Royal Canal Urban Greenway

Infrastructure Equality Audit

Issue | 30 October 2025

designed by	author	scale	sheet size
MK	JP	1:500	A1
drawing no.	revision		
170239-X-04-X-XXX-DR-DBFL-CE-1101	7

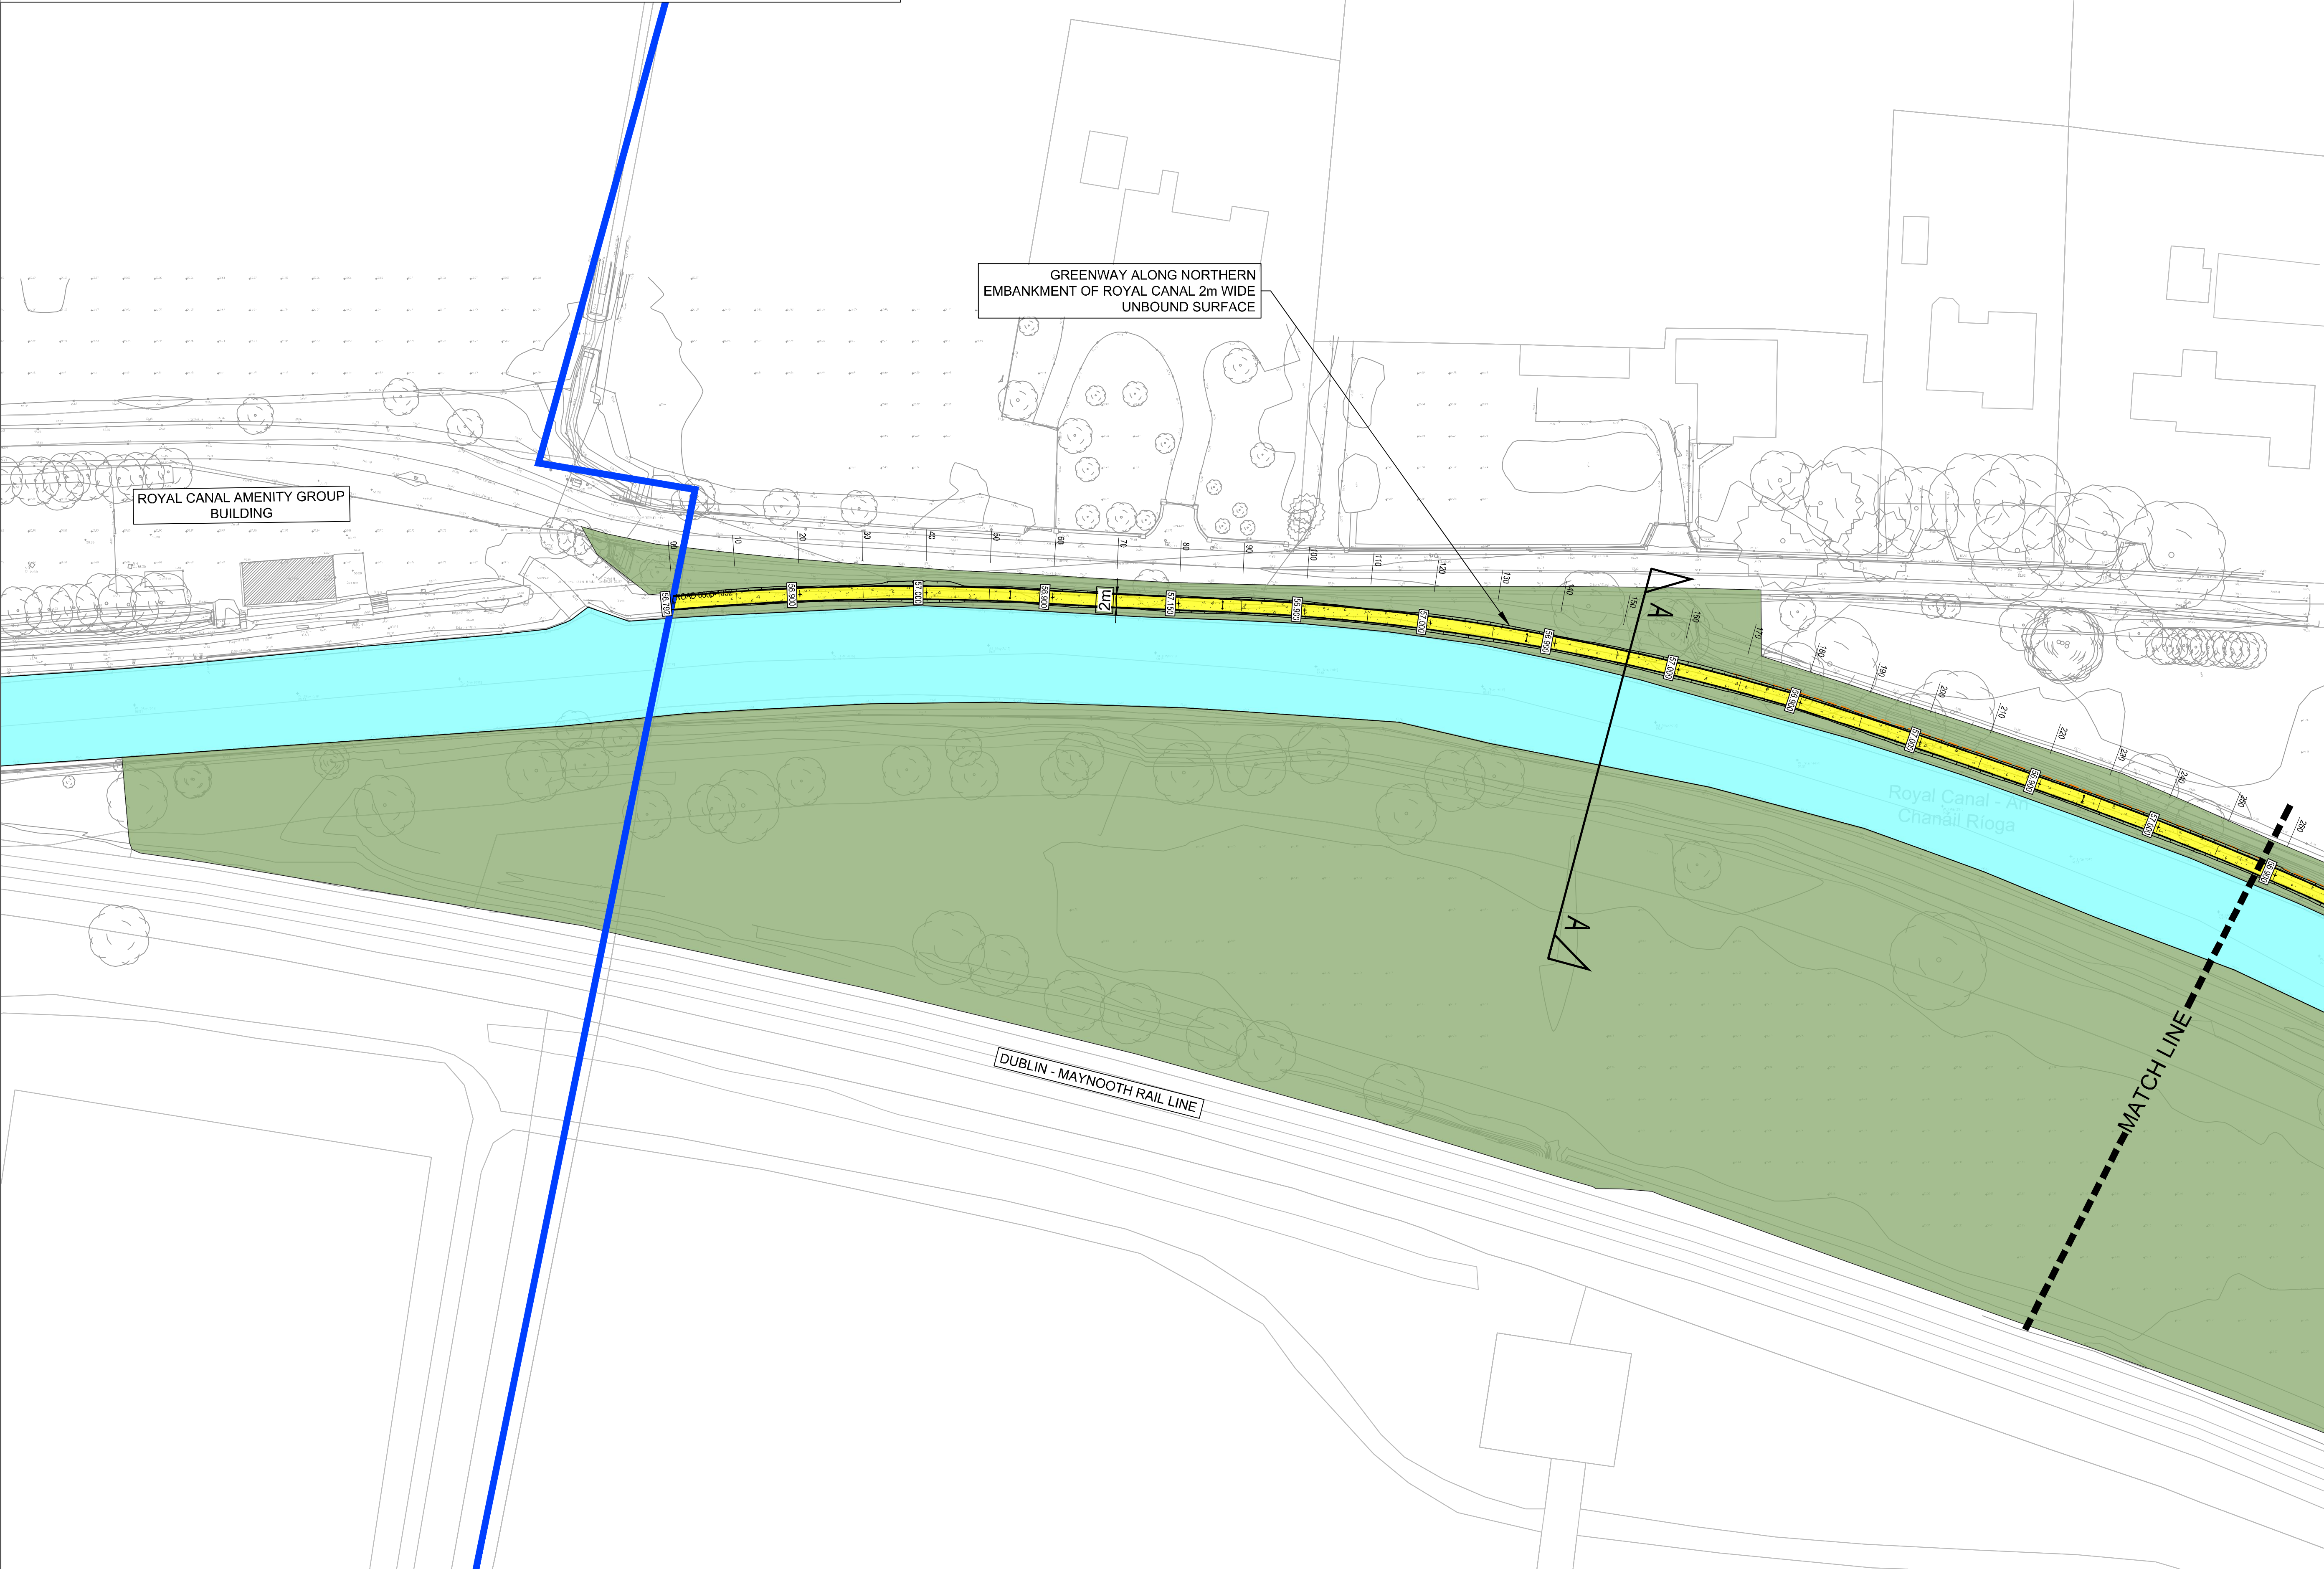
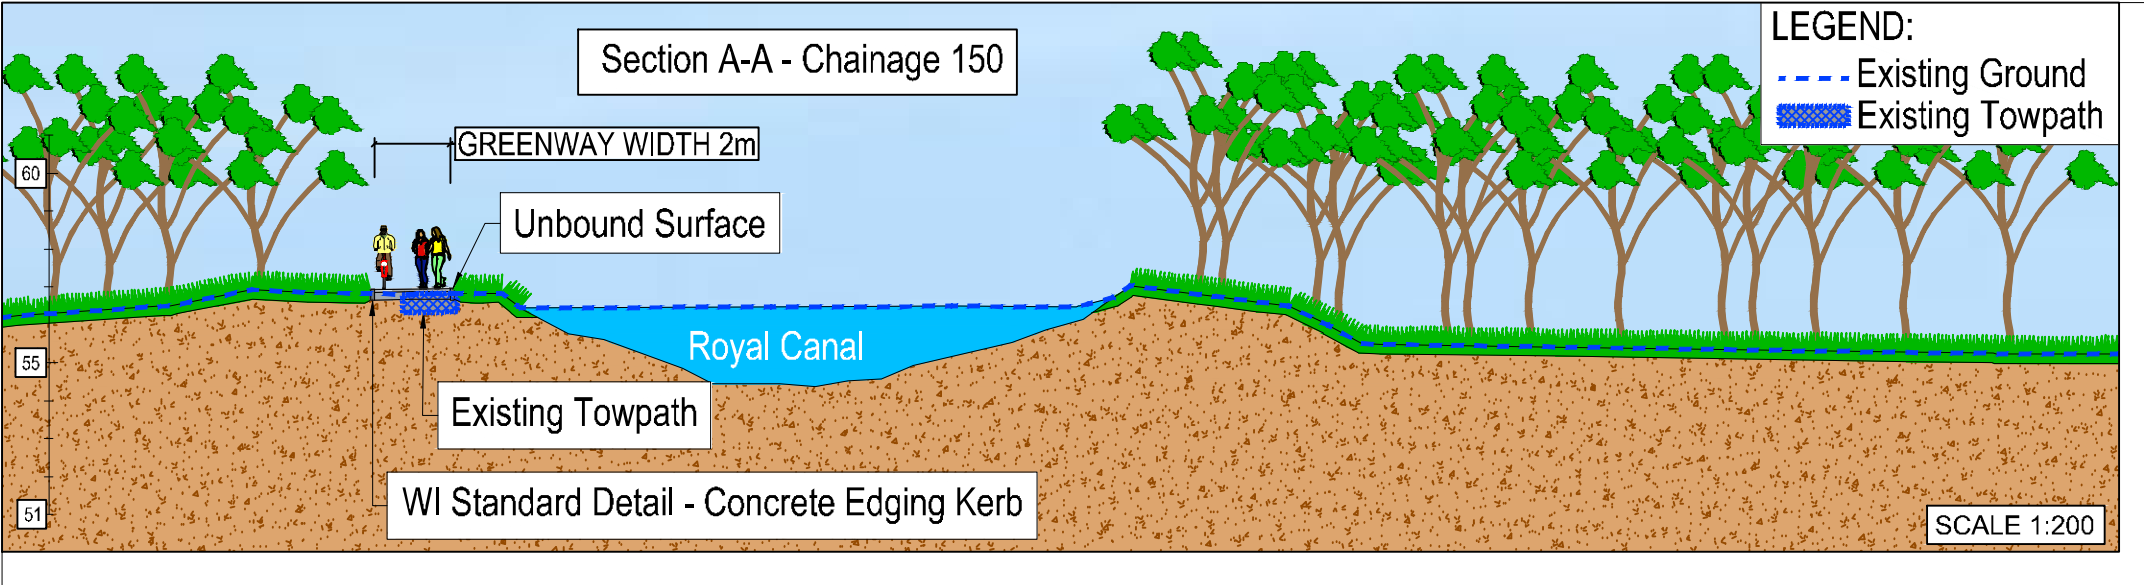
8.	Accessibility Issues	Western access to greenway is beyond boundary of the scheme by approximately 20 - 25m. Presently the surface in this area appears to be unbound and may present accessibility issues for wheelchair users, buggies etc.	0	Ensure scheme ties in appropriately.
